From: Martyn White
Sent: 01 July 2019 11:34
To: Planning.Responses <Planning.Responses@arun.gov.uk>
Subject: A/63/19/PL

A/63/19/PL

The application relates to external alterations comprising replacement shopfront, replacement main roof covering and raising the height of the rear roof. The property is located within the Angmering Conservation Area and is located in close proximity to a number of listed Buildings including, but not limited to, Blaber Cottage, 1-5 Church Road, Little Avenings, Angmering Library, the Vestry, St Margarets Church, and the War Memorial.

PROJECT
SHAFIQUES, THE SQUARE
ARUNDEL ROAD
ANGMERING
WEST SUSSEX
DRAWING TITLE
PROPOSED FLOOR PLAN, ROOF PLAN &
ELEVATIONS

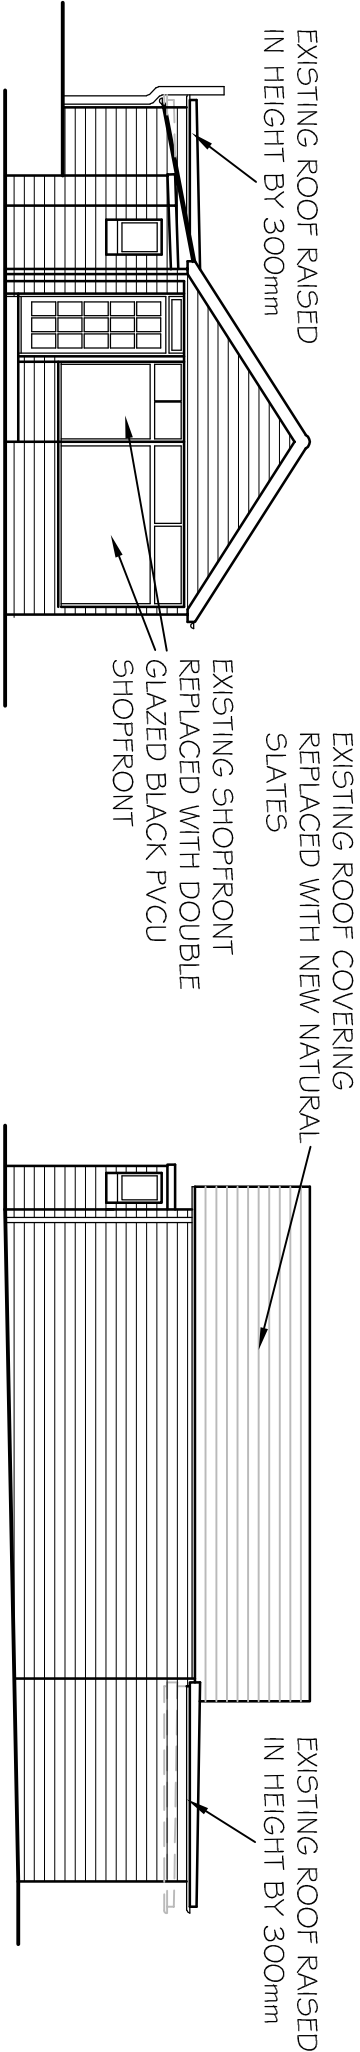
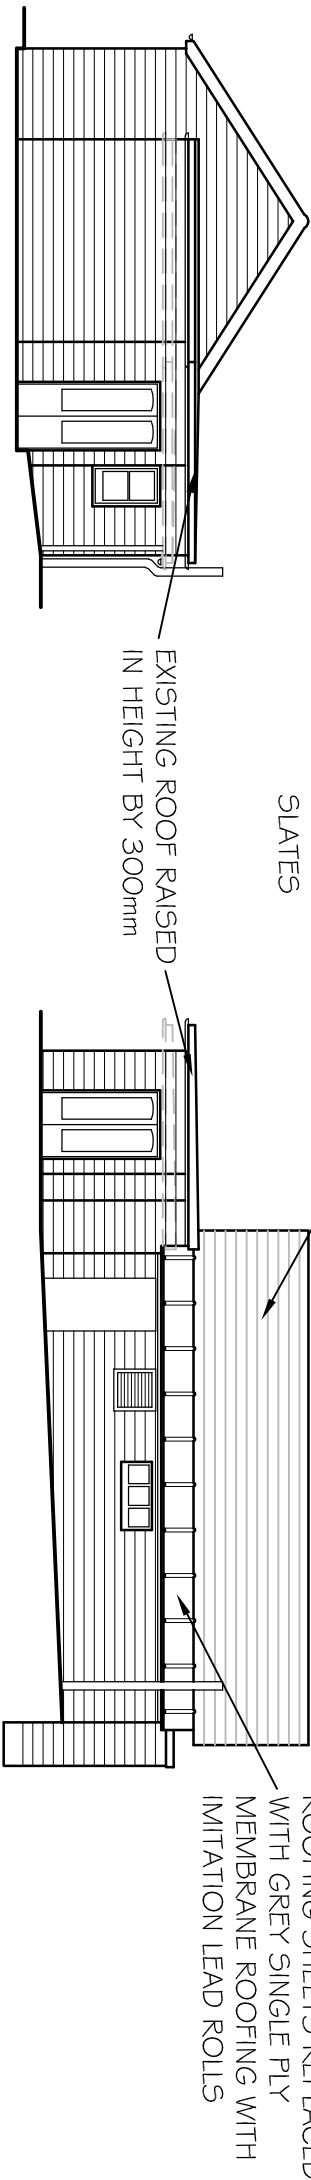
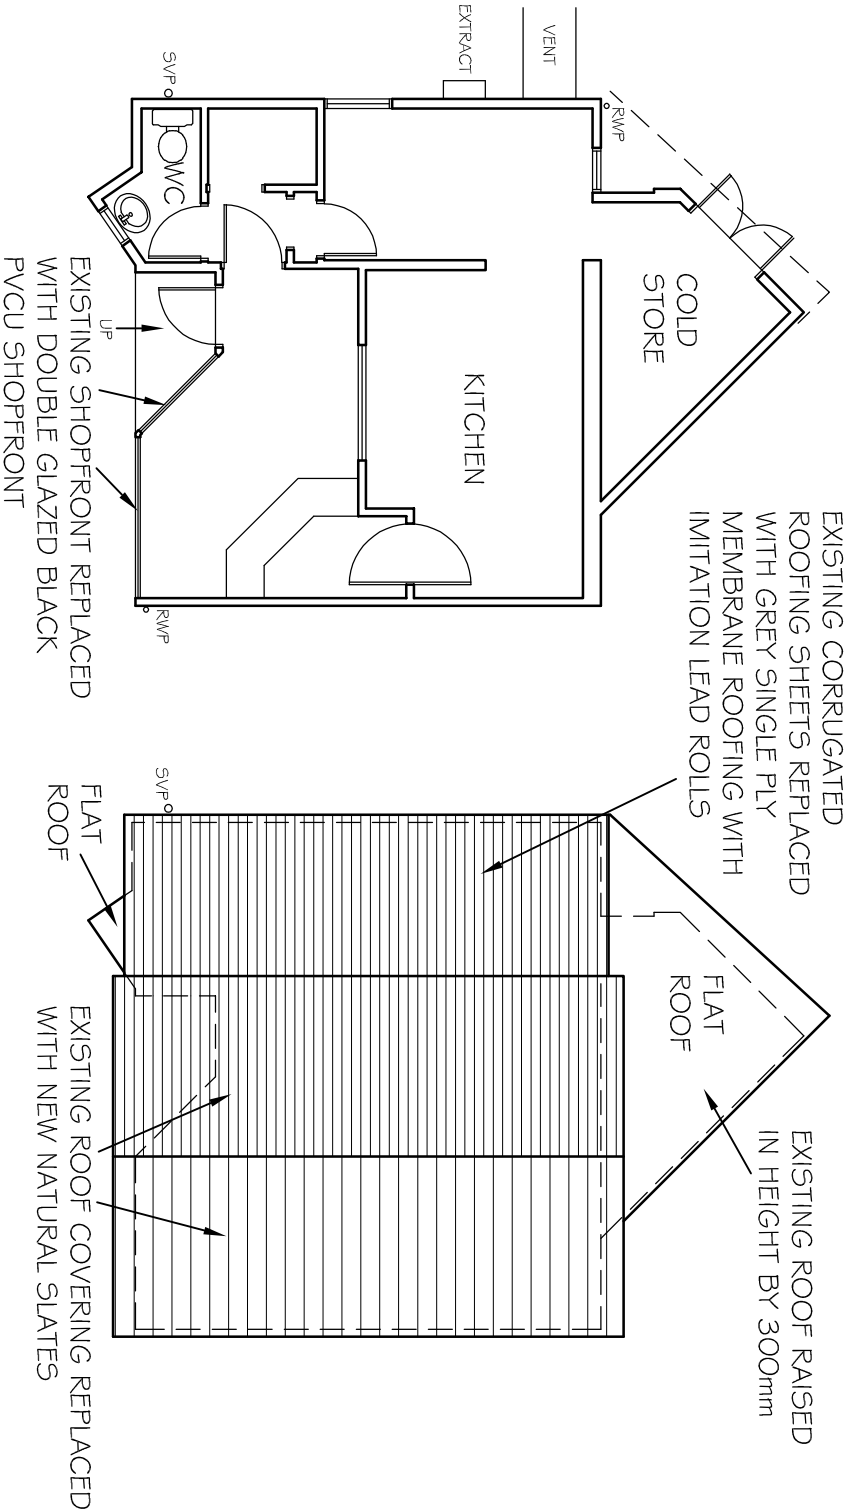
The proposal involves recovering the pitched roof with natural slate which will have a positive impact upon the character of the area, as it will ensure that a traditional material remains within the conservation area.

The replacement shop front, on the other hand will introduce a modern material into the conservation area. Such a material is considered to be inappropriate for a historic location such as this. The design, detailing and visual effect of shiny modern UPVC windows make them appear different to traditional windows, and therefore out of keeping with more traditional materials.

I should also point out that UPVC windows are also unsustainable; it is tricky to repair them, with often the only viable option being to replace them in their entirety. In addition, they require continuous cleaning to prevent discolouration from dirt and ultra violet light, and regular maintenance.

Raising the height of the roof could mean that the structure becomes more visible on the street-scene. However, it might be that the impact can be mitigated through the use of appropriate materials.
